KIRKLEES METROPOLITAN COUNCIL INVESTMENT & REGENERATION SERVICE

DELEGATED DECISION TO DETERMINE APPLICATIONS FOR CONSENT, AGREEMENT OR APPROVAL REQUIRED BY CONDITION

Reference No:	2025/44/90030/W
Site Address:	rear of, 1, Sparks Road, Oakes, Huddersfield, HD3 4BX
Description:	Discharge of details reserved by conditions 4 (bird/bat box), 5 (road marking), 6 (access), 8 (Phase I Desk Study Report), 13 (materials) on previous permission 2023/90956 for erection of 4 dwellings
Recommending Officer:	Molly Storer

DECISION – DISCHARGE OF CONDITION – SPLIT DECISION

3. Proposed Rear (West for Plots 1 & 2, South for Plots 3 & 4) Elevation  
Scale 1:50

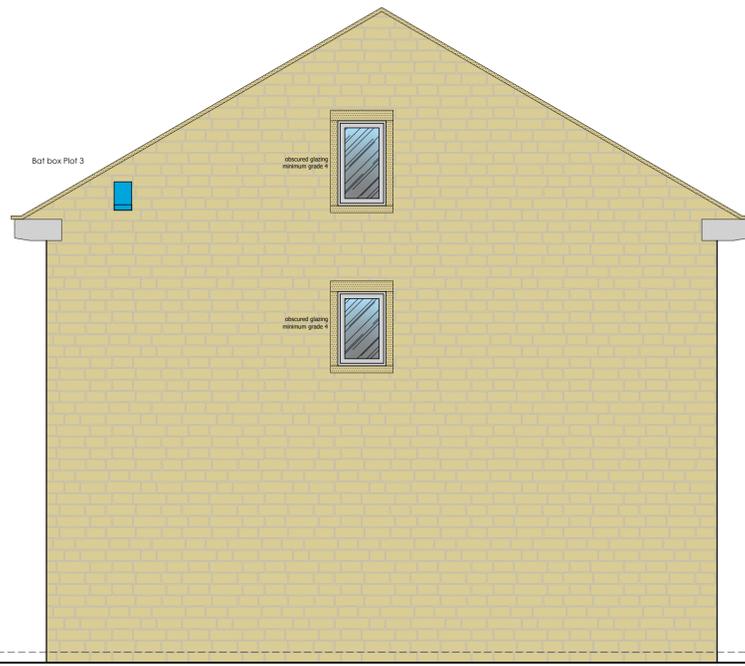
The submitted plan shows the location of a sparrow box on the proposed rear (west) elevation of plot 1 and 2 bat boxes, one on the side (north) elevation of plot 2 and one on the proposed side (east) elevation of plot 3. These locations are considered acceptable.

The submitted information is considered sufficient for the discharge of condition 4.
